**From:** [Jeremiah Cromie](#)  
**To:** "Chris Cruse"  
**Cc:** [Arden Thomas](#); [Justin Turnbull](#); [John Schultz](#); [Dan Carlson](#)  
**Subject:** RE: BL-22-00020 Schultz - Request for Updated Survey/Clarification  
**Date:** Monday, November 14, 2022 3:29:04 PM  
**Attachments:** [BL-22-00020 Schultz Preliminary Final Survey Review 10-27-22.pdf](#)

Please see the attached survey comments from the final preliminary survey for Boundary Line Adjustment application BL-22-00020 Schultz. Can you please provide clarification on items 1, 4-6 in the survey comments memo or provide an updated preliminary final survey? I have also included what was sent for the final preliminary survey and lot sums for this BLA.

SCHULTZ PROPERTY

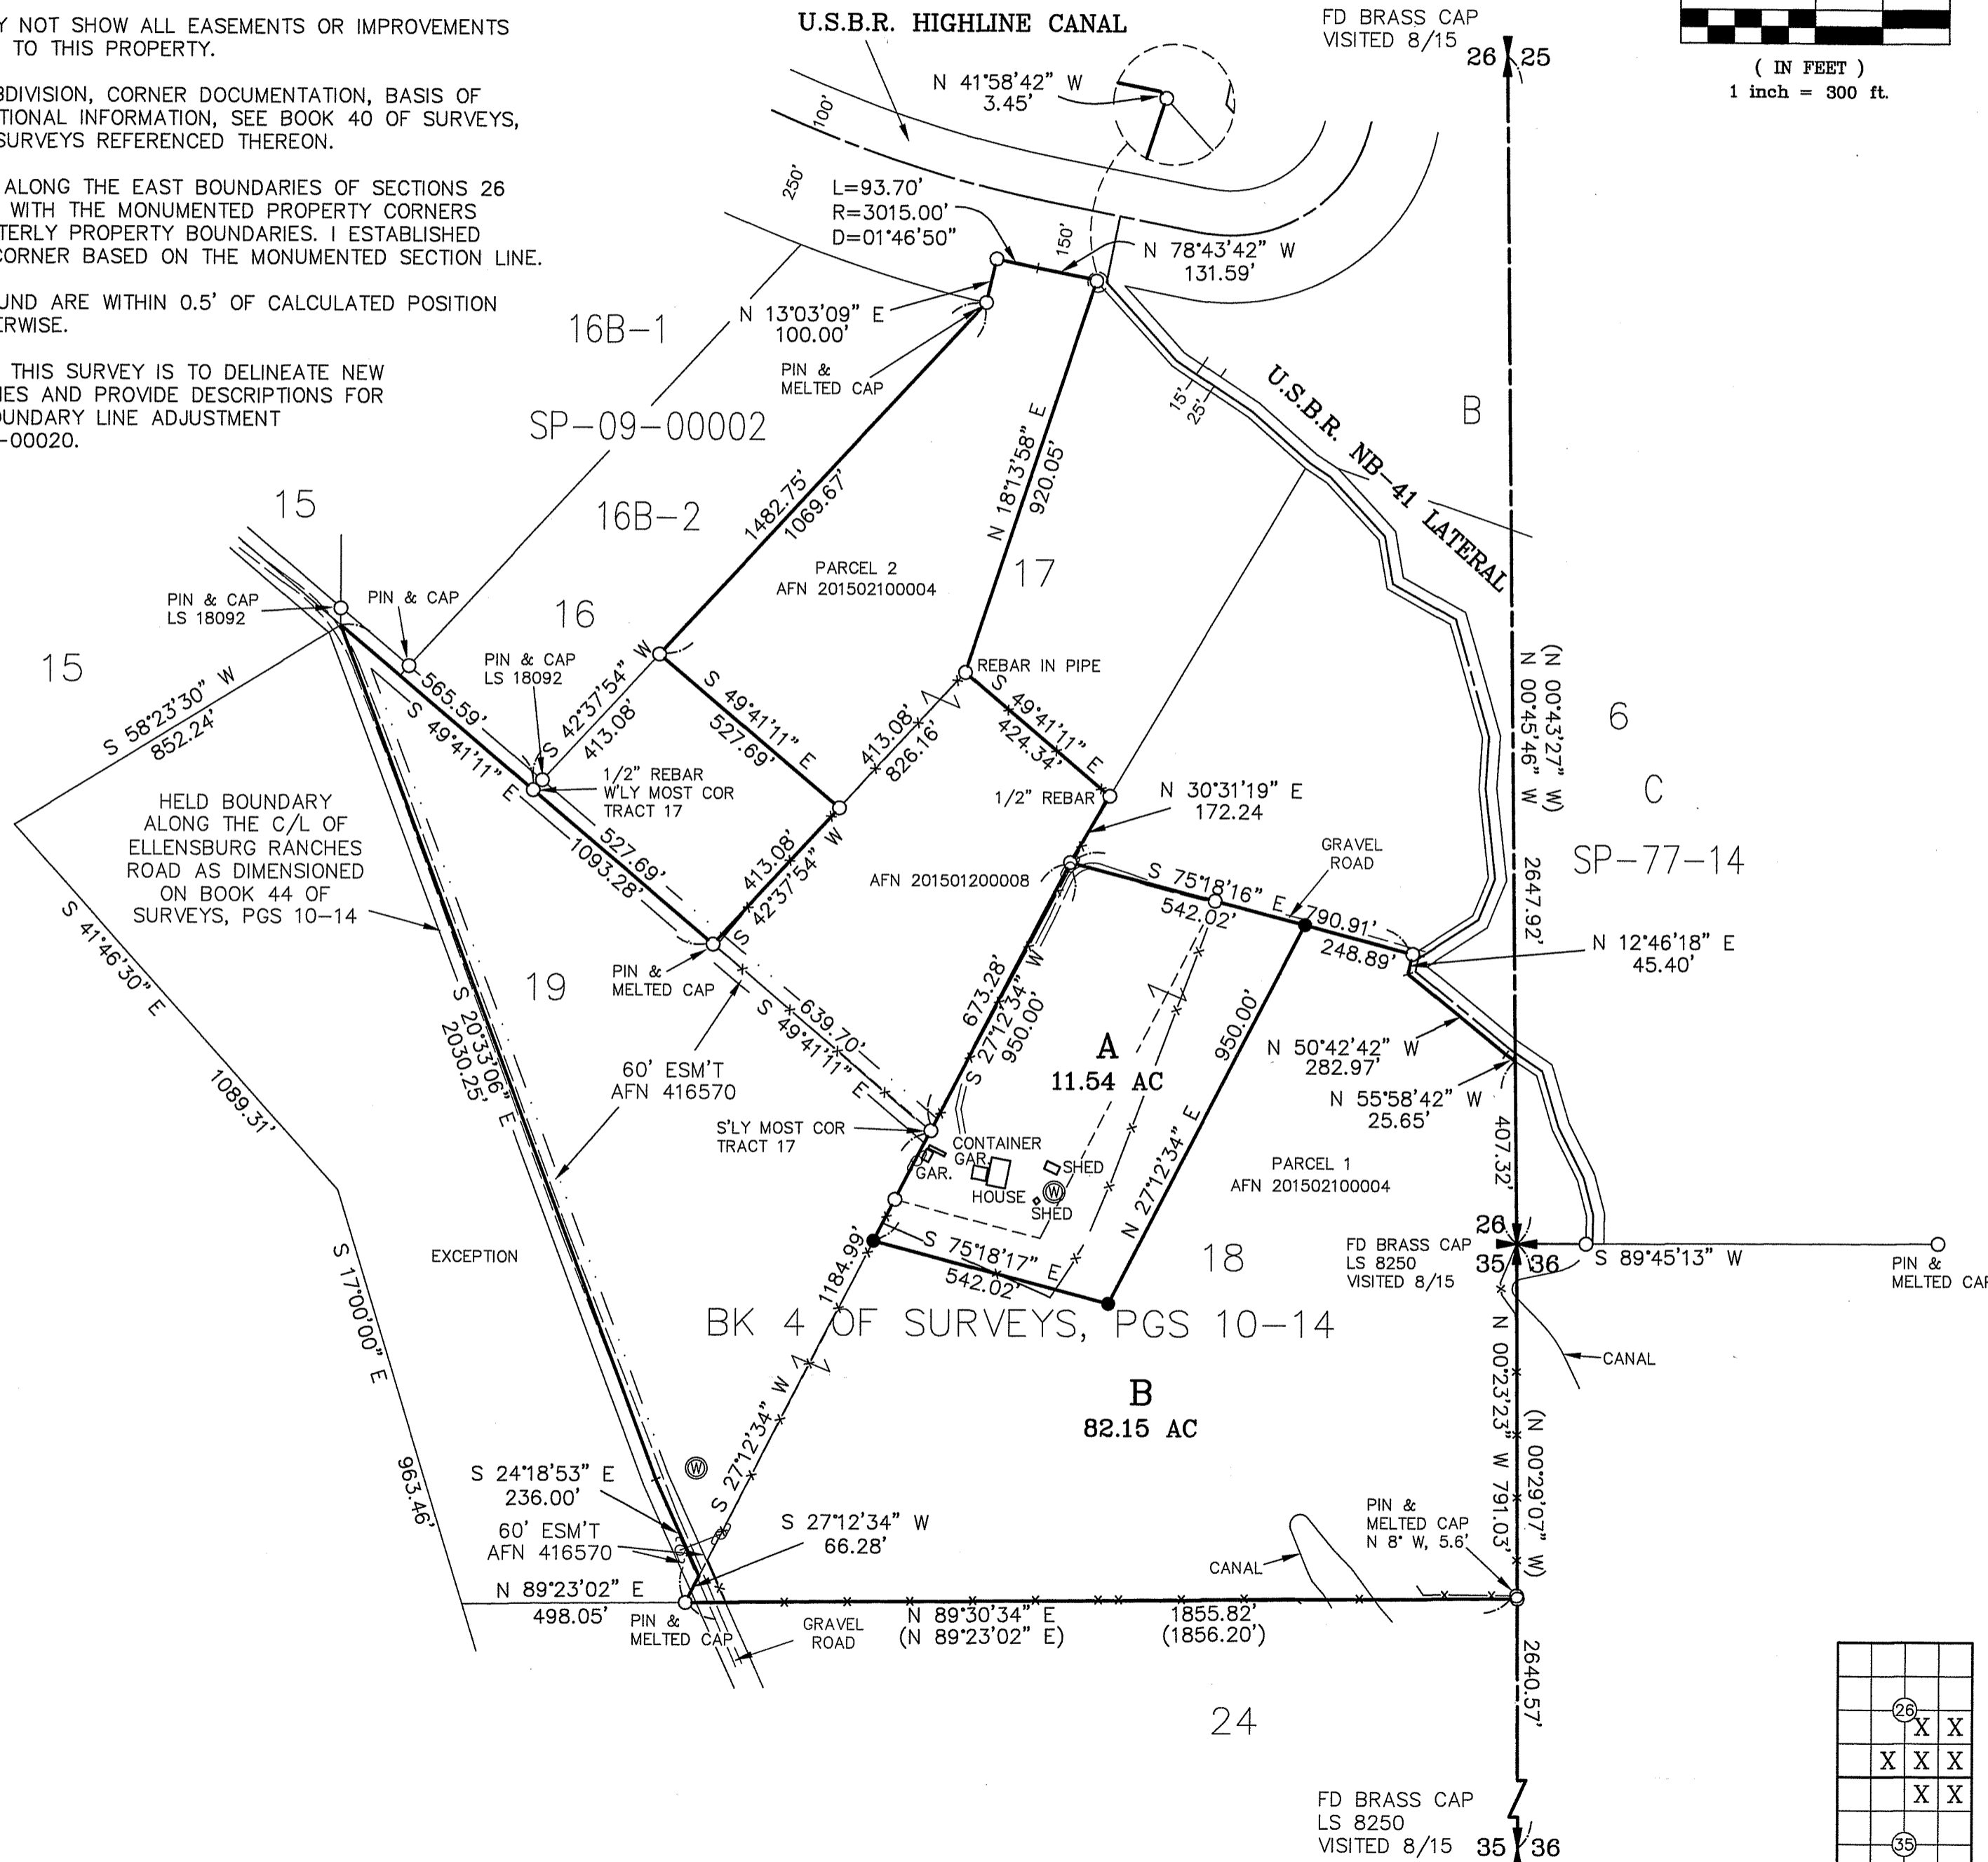
After review of the survey and aerial photos (including historical), the county is not requiring any pond to be delineated on this Survey/BLA. Please be aware of streams and ponds for future surveys however.

As for the ownership piece in your questions, it is required under RCW 58.17.255 and WAC 332-130-050 (1)(B)(f)(vi) and WAC 332-130-050(1)(B)(f)(vii). Your previous survey that was included in the application submittal included this triangle piece. Any ambiguities, trespasses or hiatuses (gaps in ownership) need to be noted on the face of the survey (not necessarily corrected).

Please provide an updated Survey showing this along with comments 1, 2, 3 & 5 as you described to continue processing the Boundary Line Application.

The portion falling in Section 25 is shown both on the Compass GIS map as well as a prior survey by you (SUR: 40-30), as well as being excluded by prior adjacent survey (SP:A-29). The concern is that unless you or the title company can place the portion correctly to another parcel number, it MAY cloud the title and be perceived as an illegal division of land.

Understandably this MAY be more involved than what you (or your client) are prepared to do. If this is the case, please just note the possible gap in ownership on the face of your survey.
